From: Amanda Scholes on behalf of Planning.Responses
Sent: 27 April 2018 08:22
To: Planning Scanning; Karen Parsons
Subject: FW: 1 Seaton Road LU/33/18/HH

From: Mark Jones [REDACTED]
Date: 20 April 2018 at 12:13:18 EEST
[REDACTED]
Subject: 1 Seaton Road LU/33/18/HH

ELEVATIONS AS PROPOSED

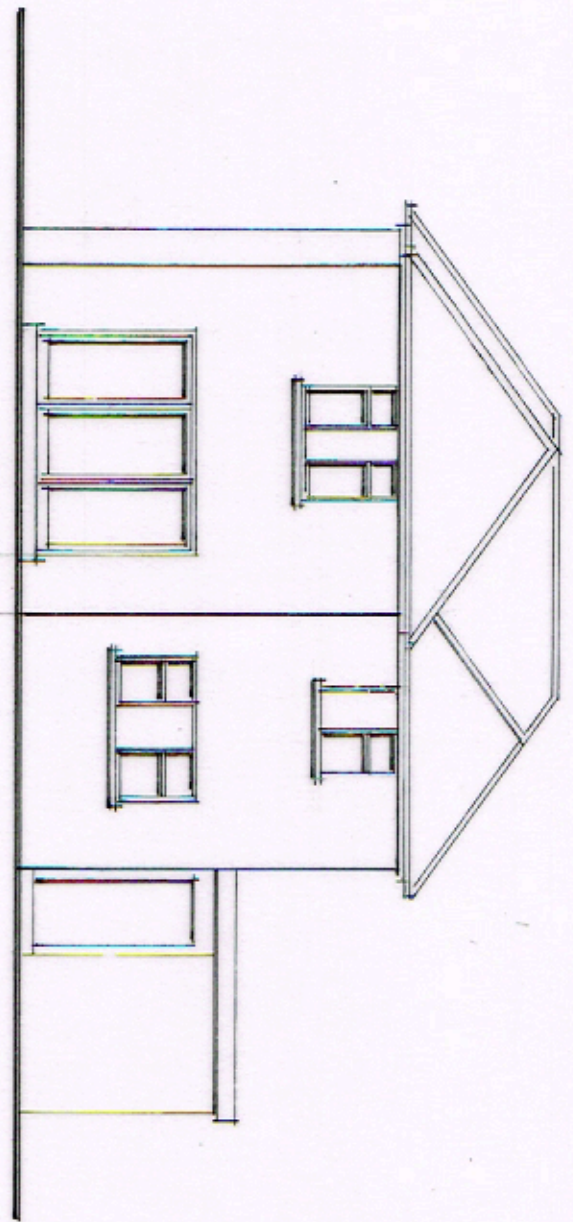
The neighbouring property No.3 has what appears to be a bedroom window in rear elevation set back behind the rear building line of No.1. My concern is the impact of the two storey extension on the this habitable room. To assess such matters the Council usually take a 45 degree line off the centre point of the nearest window. In this case this line is breached and I feel that the two storey extension will have an adverse impact upon this window and the amenity of the adjoining occupiers.
